From: Geoff Thorpe [REDACTED]
Sent: 27 June 2019 10:59
To: Planning
Subject: Applications AB/48/19/PL and AB/49/19/L - for the attention of Mrs Gardner

A6001-05

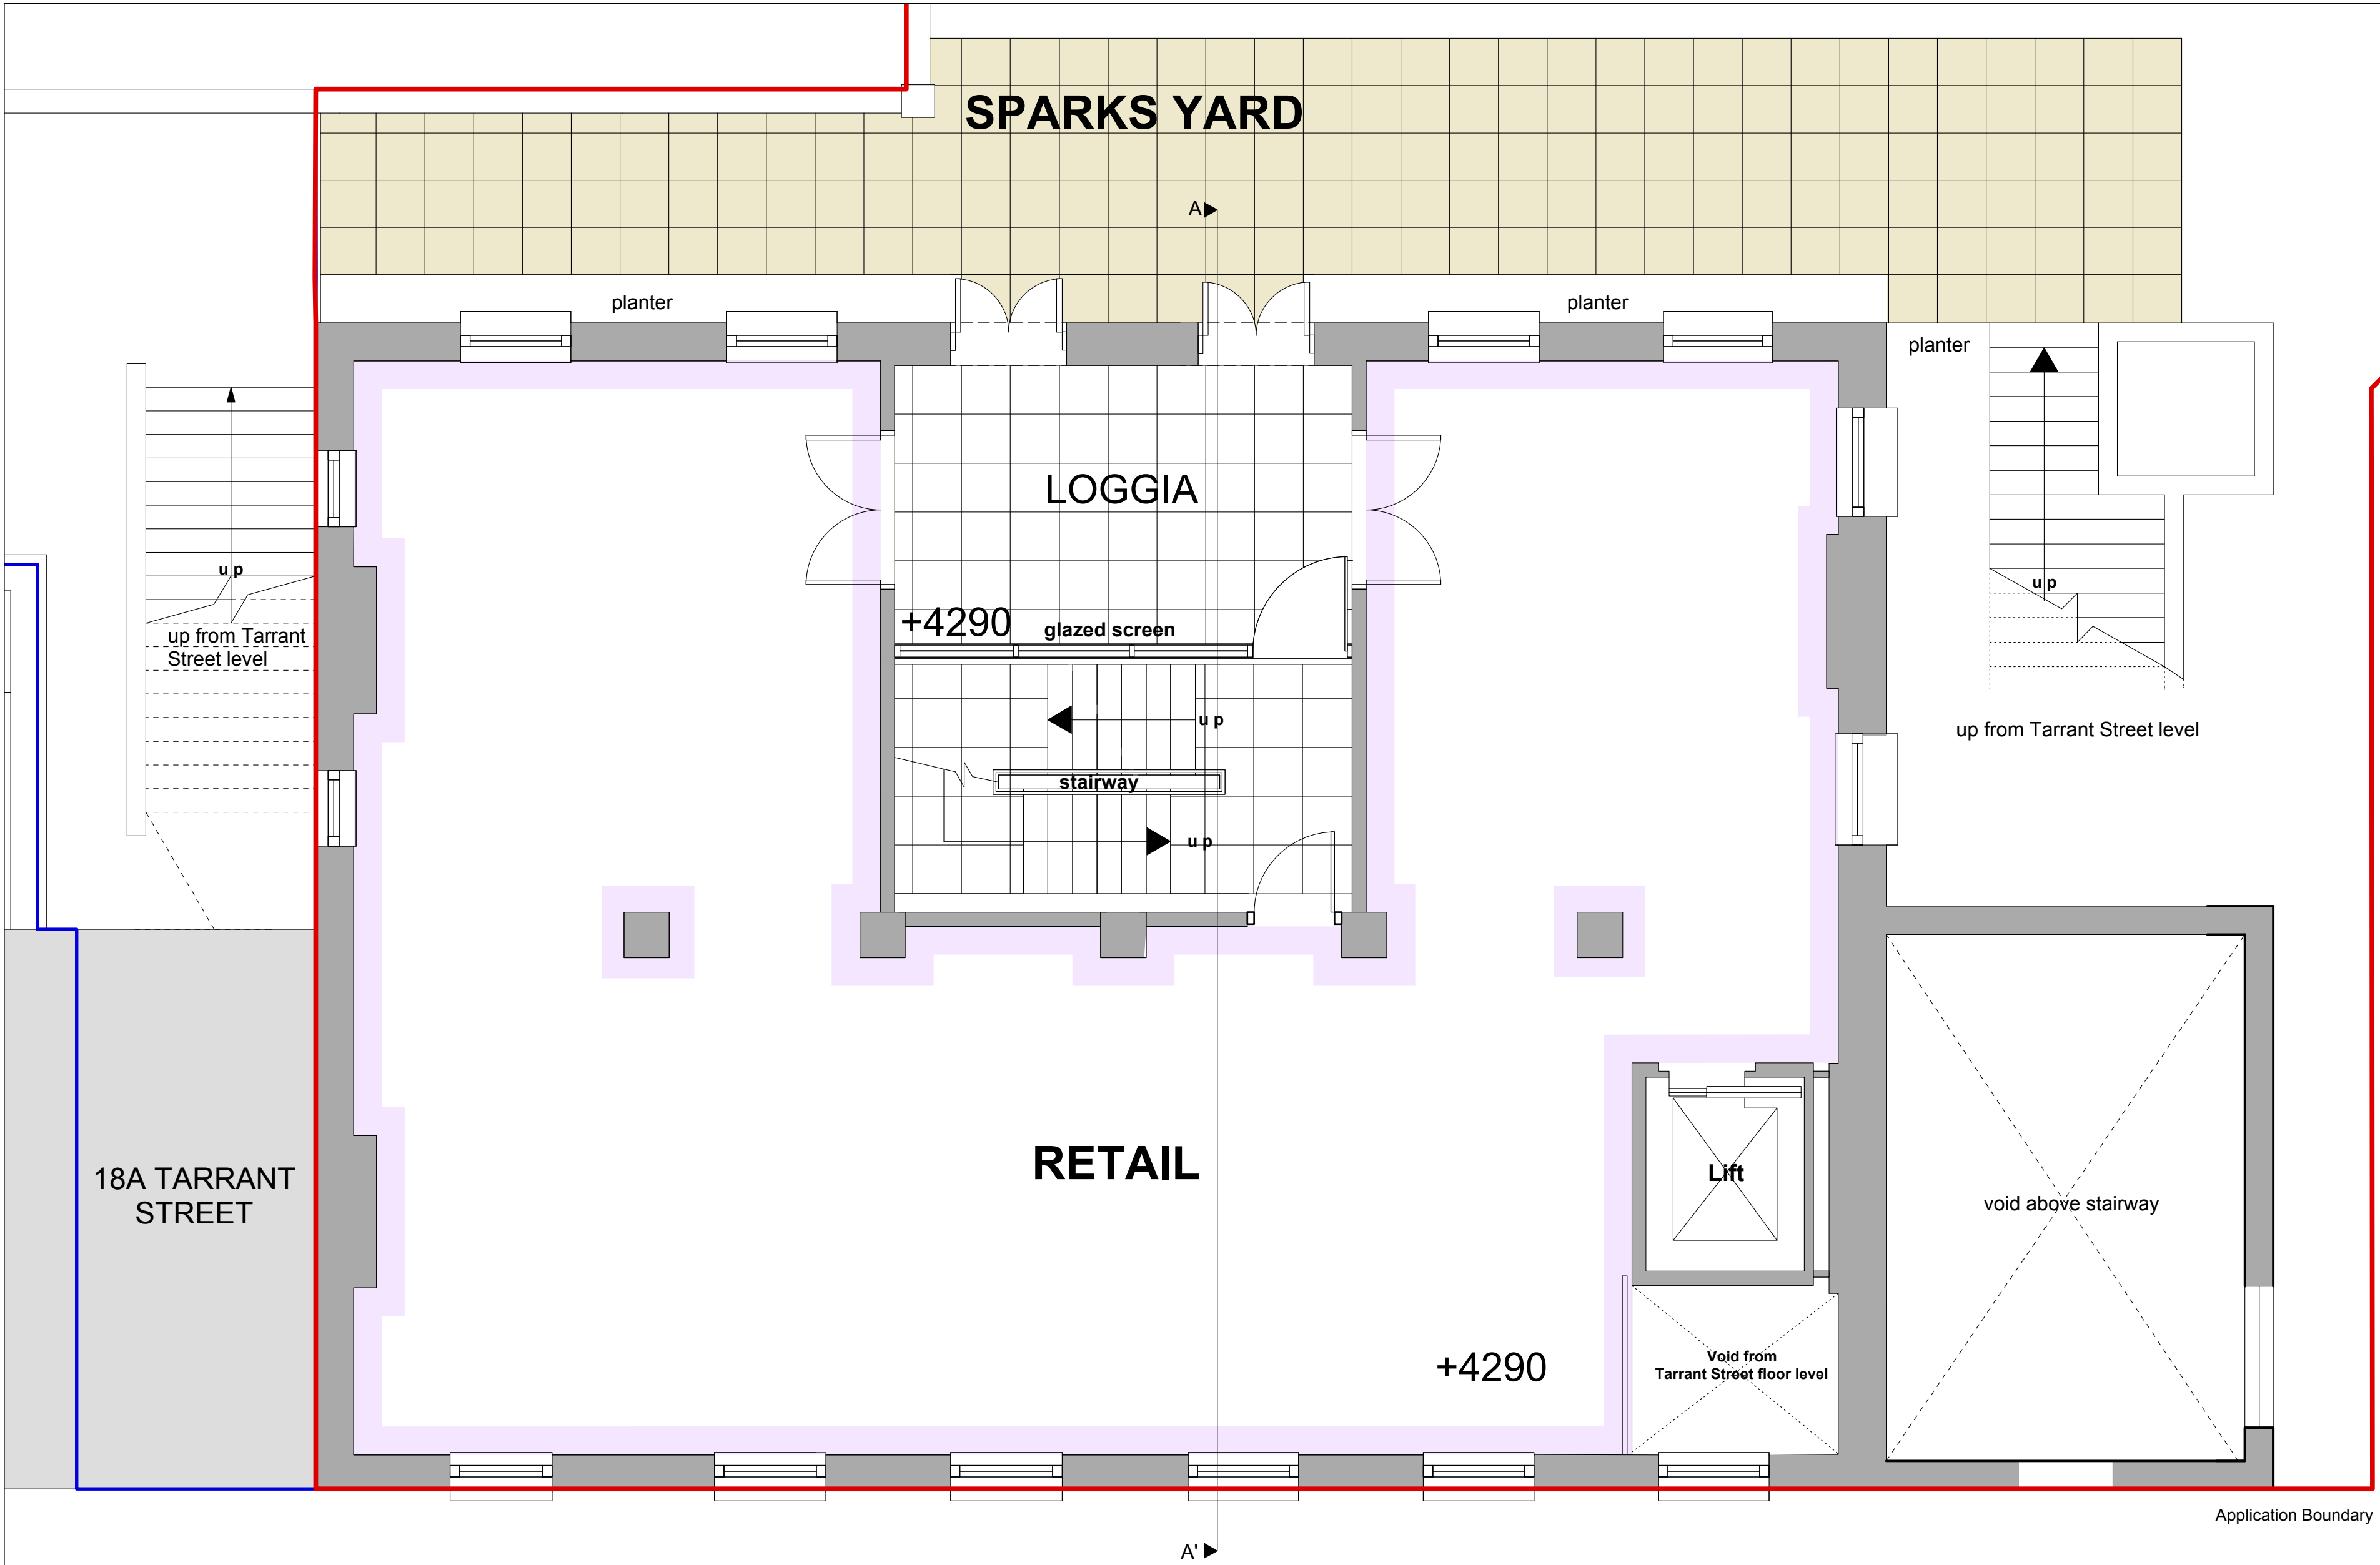
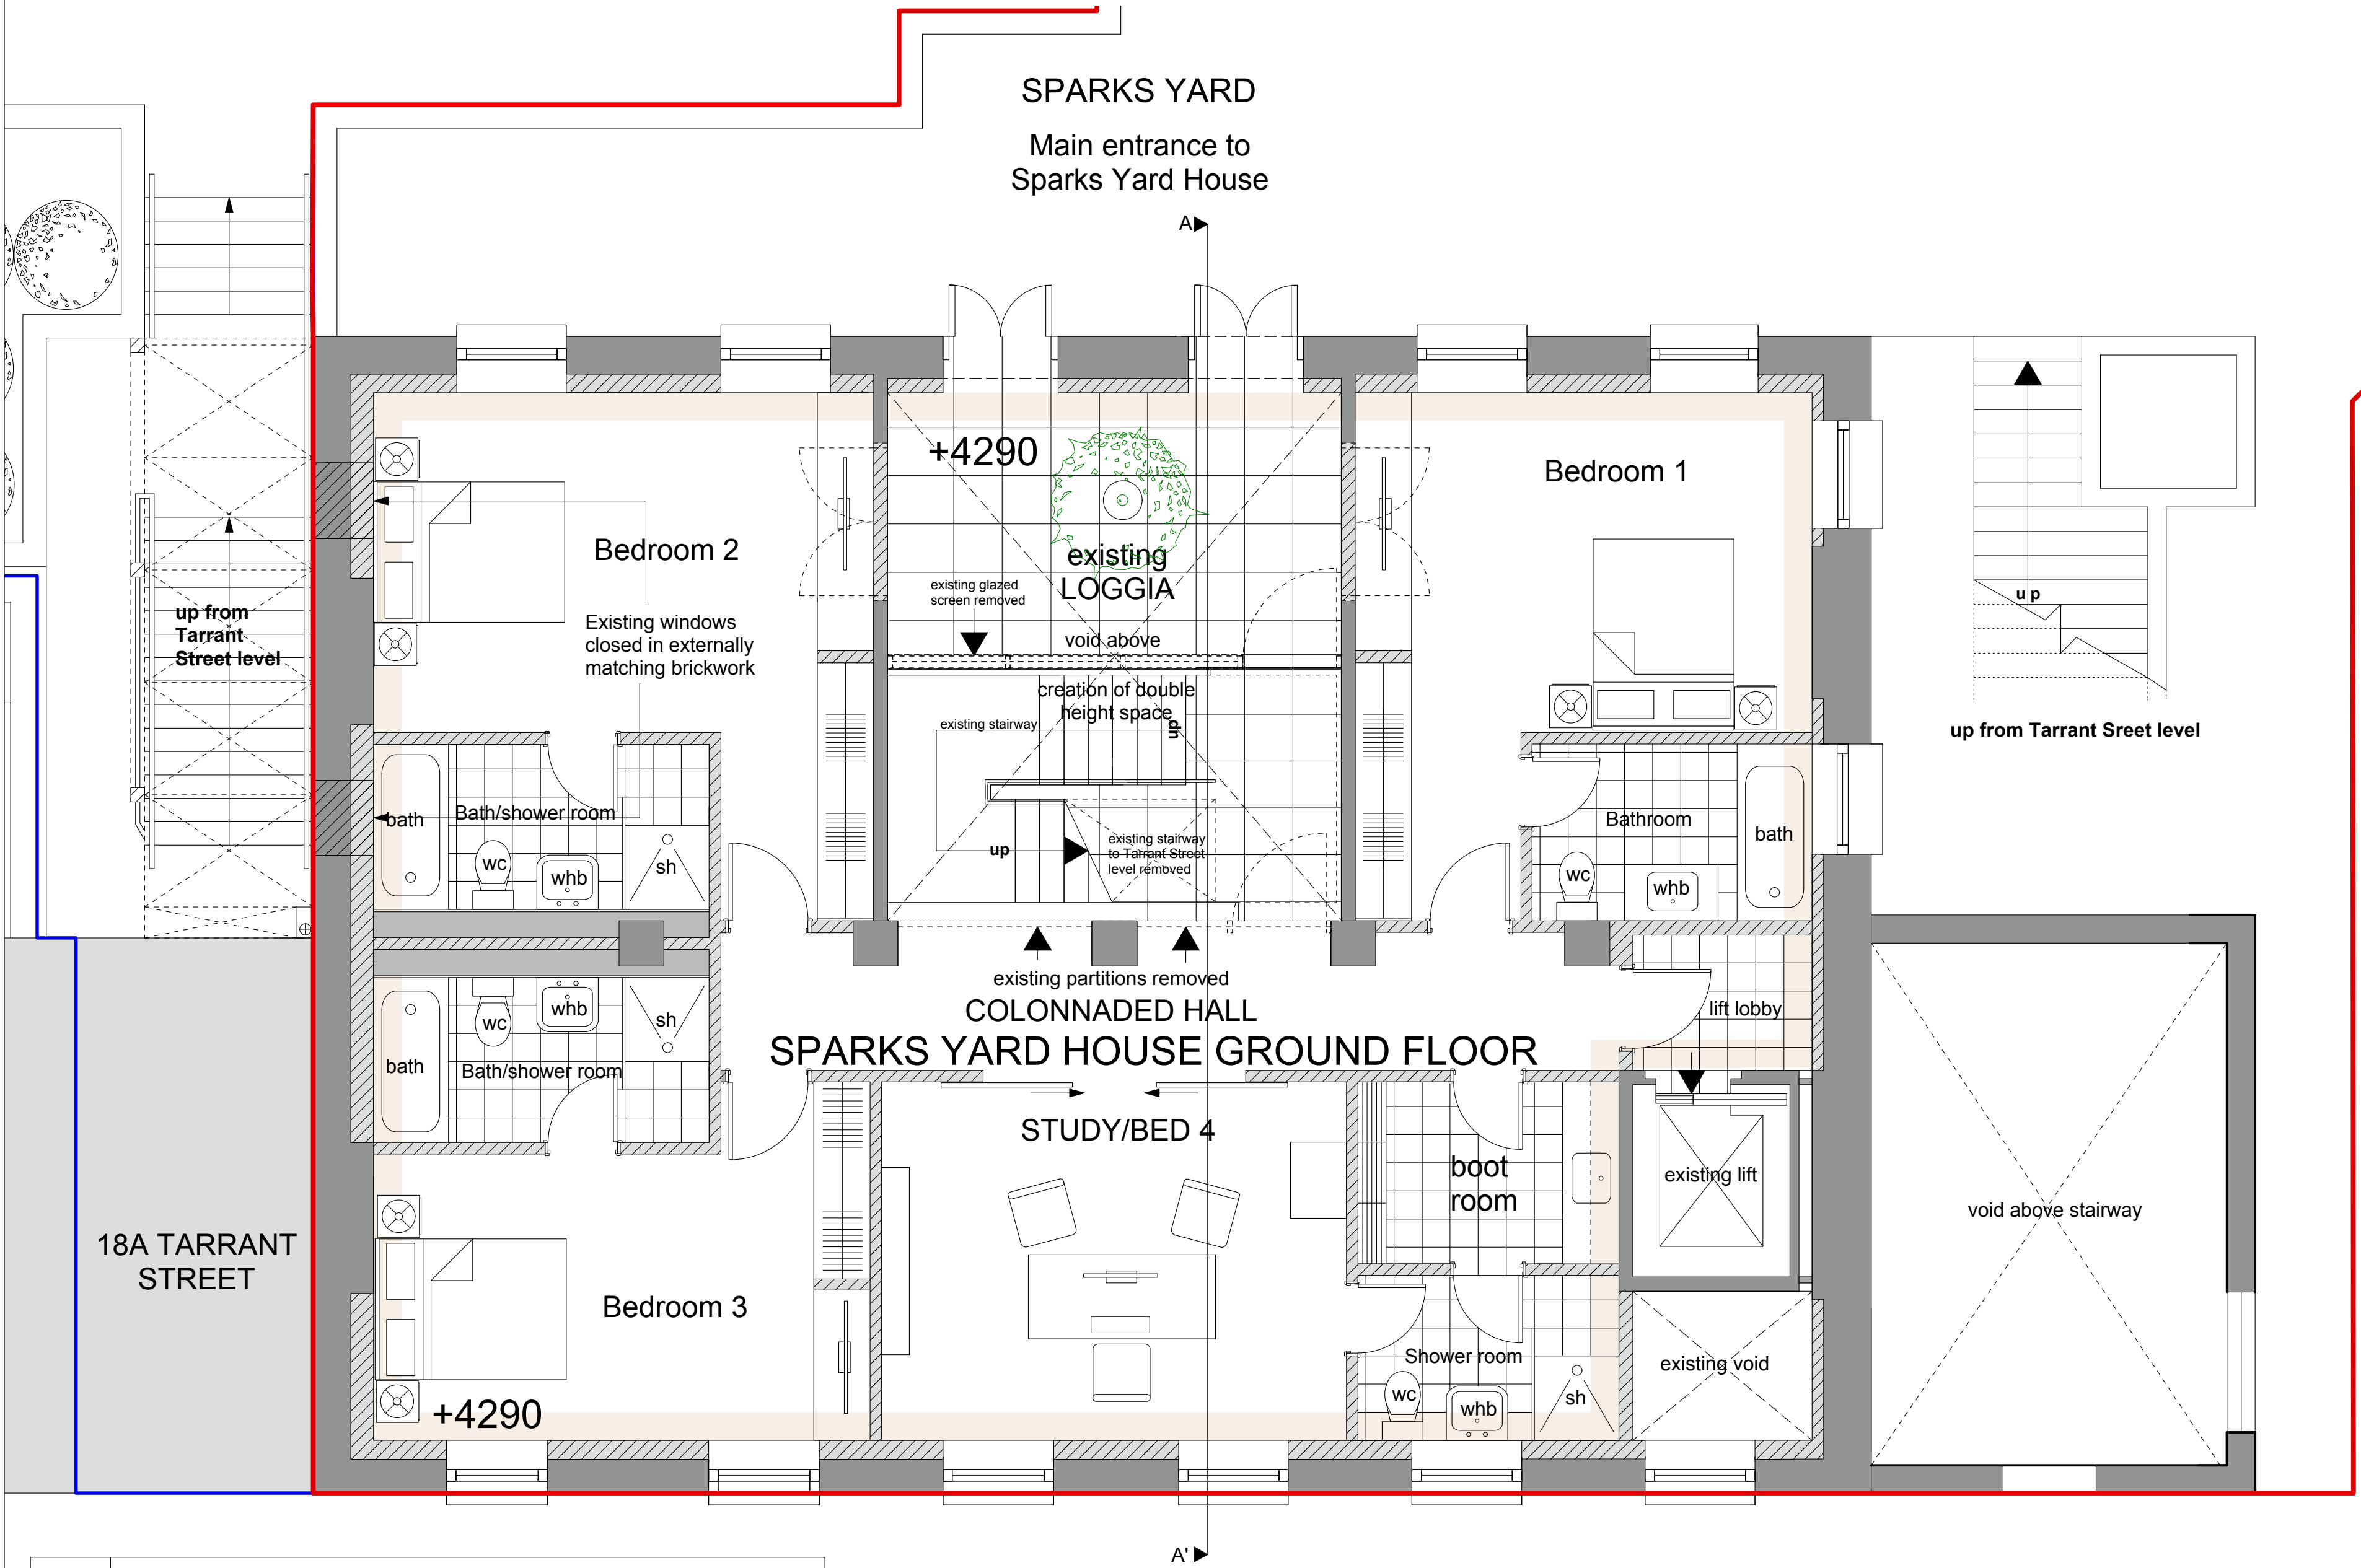
2. I am delighted to read the concerns relating to the lining of the external brick walls with insulation and plasterboard. We do not wish to do this and it was only included in the proposal in order to satisfy the inevitable thermal insulation requirements of building regulation approval. I confirm therefore that we wish to amend our applications in order to remove all proposed external wall linings to the upper two floors of the buildings and will seek an agreement to relaxation when the building regulation approval

application is made, citing its unacceptability for inclusion within this listed building. Would you like us to submit amended drawings to cover this or can this be covered by a potential condition?
